Our Ref: P/46/19/HH

**Town & Country Planning Act 1990 (as amended)
Town & Country Planning (Development Management Procedure) (England) Order 2015
Application for Householder Planning Permission**

Development Retention of chairlift on front elevation.
Location 8 Laurel Drive Mill Farm Estate Pagham

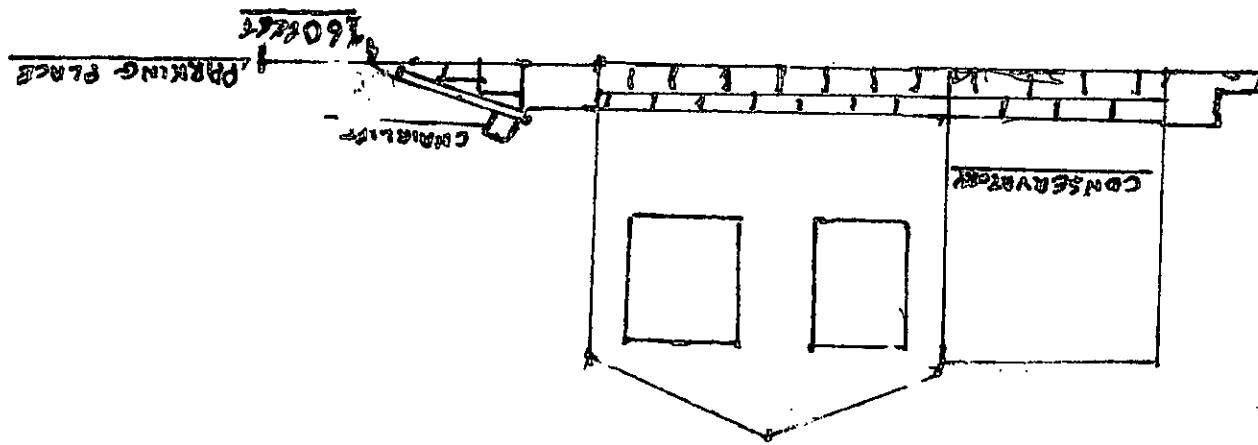
1. Plan View - please draw an arrow showing the direction of North
2. This plan is drawn at 1:100, please show the measurements at this scale in metres.
3. Please label this as Proposed Front Elevation, and also provide a plan showing the Existing Front Elevation.
4. Please sign and date the enclosed copy of Certificate A.
5. Please provide details of the proposed chairlift. This can be photos or a copy of the manufacturers brochure.
